**From:** Sue Howell  
**Sent:** 20 April 2017 15:26  
**To:** Claire Potts  
**Cc:** Lucy Harding; Joe Russell-Wells  
**Subject:** RE: AL10716RES - revised plans (email 1)

Further to submission of revised plans Dwg No BDWS20440 11G sheets 1-4 re landscaping/Revision G additional planting to central pond, I can confirm that they do now contain sufficient information following our request for additional landscaping to the pond areas. We note also now the inclusion of the provision of 1.2m high post and rail fencing to pond surrounds as shown and discussed.

**From:** Wright, Aaron [REDACTED]  
**Sent:** 12 April 2017 16:47  
**To:** Claire Potts  
**Cc:** Lucy Harding  
**Subject:** AL10716RES - revised plans (email 1)

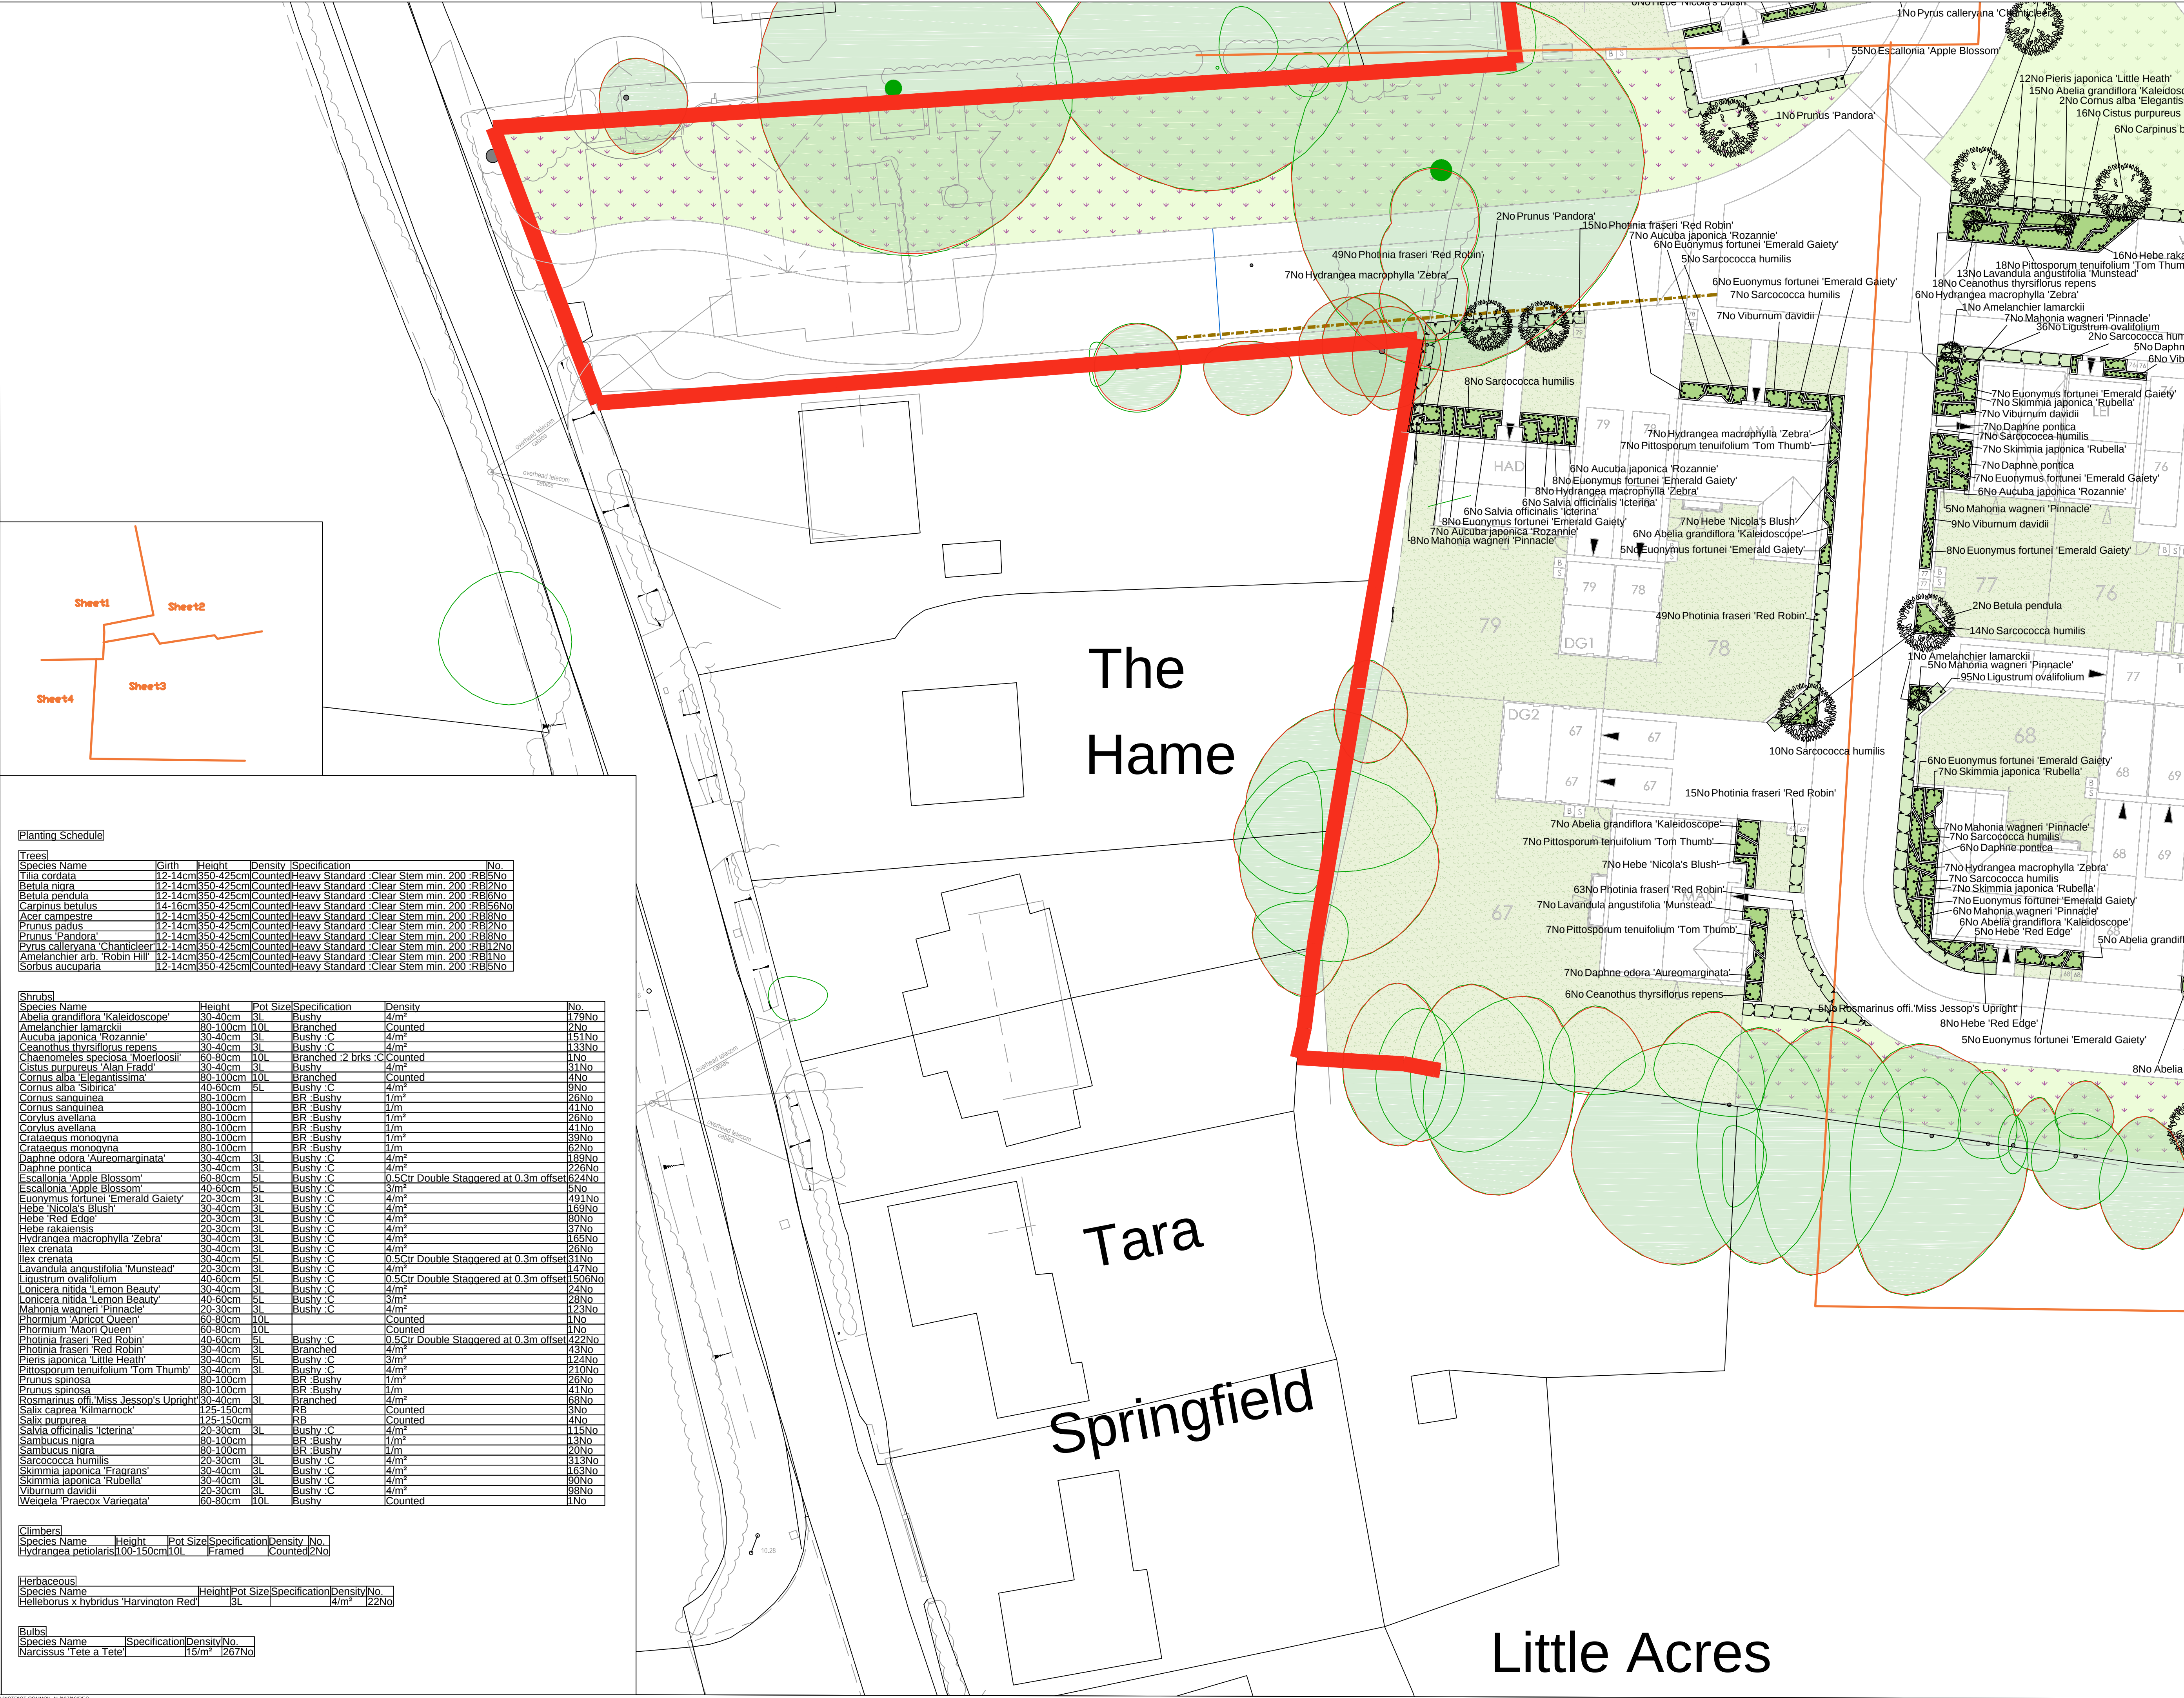
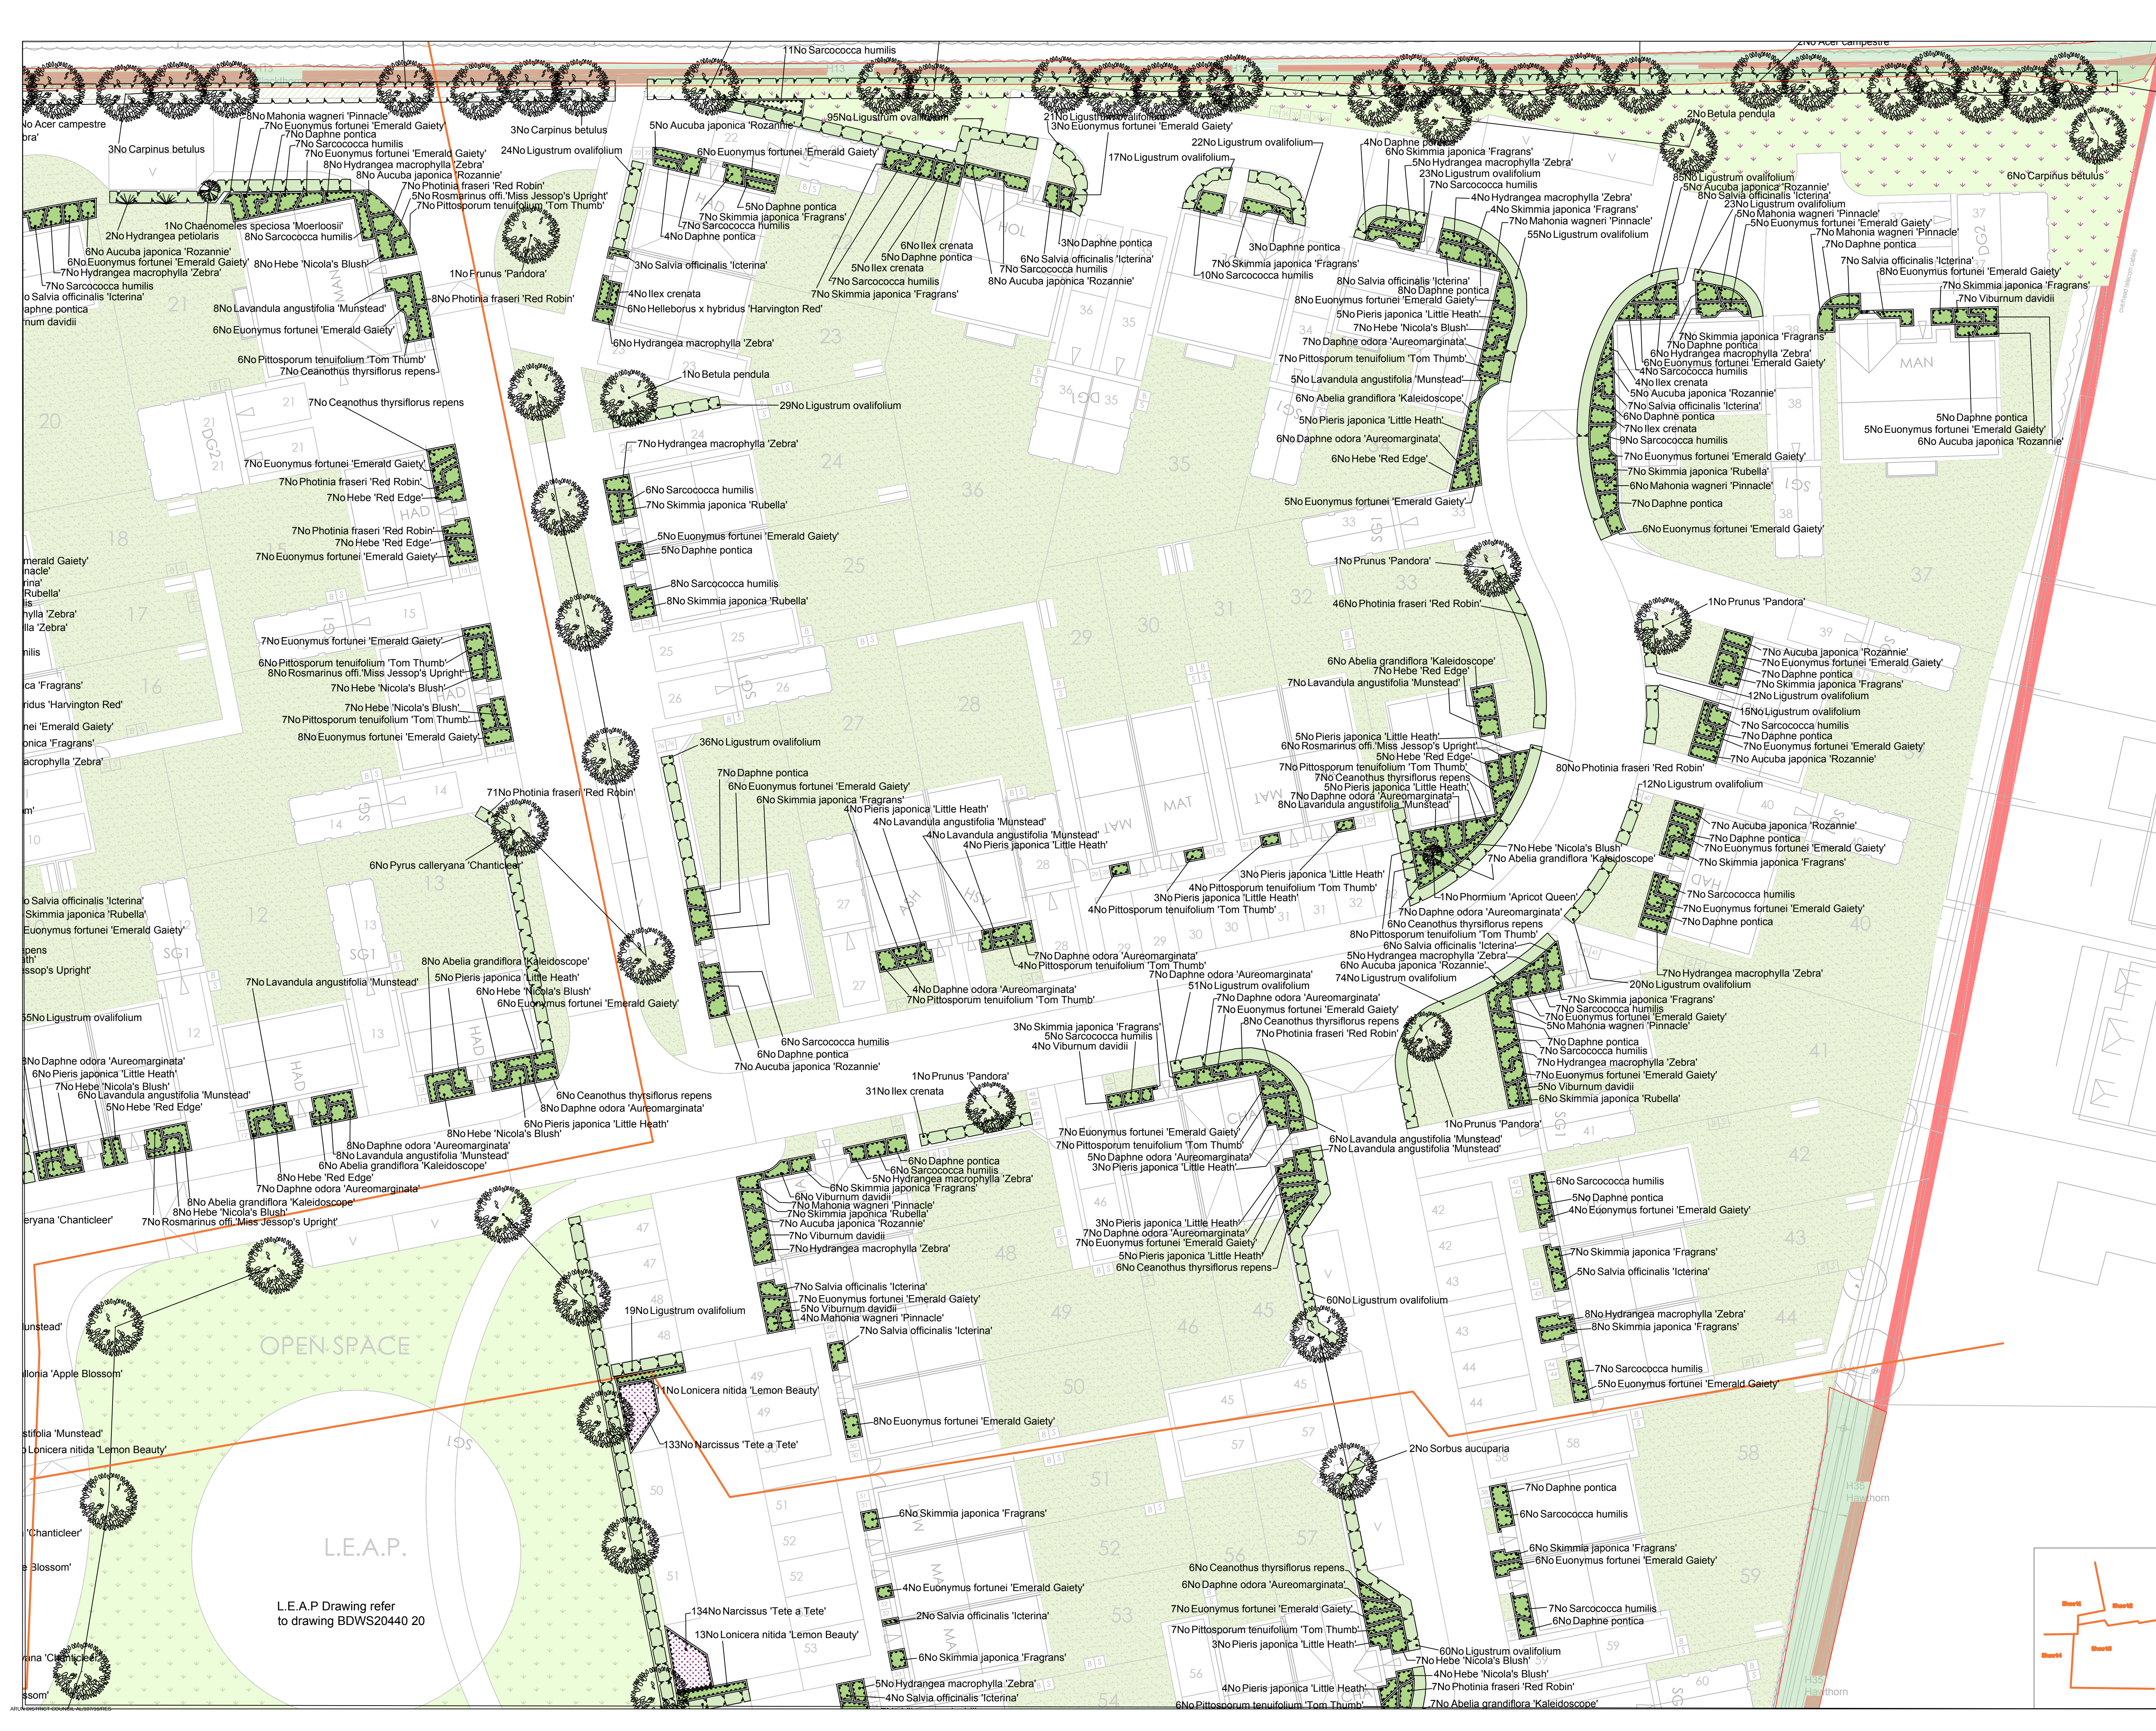
I have had a look at the attached revised plans, which the general landscape arrangement across the drawings is fine. We had however discussed some provision of planting to the periphery of the central balancing pond adjacent to the LEAP, which does not appear to feature on these plans?

There is now a very token of planting to the balancing pond adjacent to the pumping station (7no Salix) but nothing detailed to the central one? Which is where we would have liked to have seen the addition of some groupings of water tolerant planting. Not sure if this is an intended omission or if the developers were given this feedback or not?

In summary the general Landscaping scheme is fine, so too is the addition to provide a 1.2m post and rail fence to the pond edges, we would however recommend the addition of further planting be proposed to both of the balancing pond edges.

- 3m easement along the eastern boundary adjacent to the ditch, as requested.
- Landscaping drawings amended to reflect the comments of the landscape officer.

Lucy,  
Please find attached the revised landscape drawings. The plans show SUDS Wildflower Turf (WFT-SUD-37) as supplied by Wildflower Turf of similar and approved, within the balancing ponds. The ponds are shown to be enclosed by a 1.2m post and rail fence.
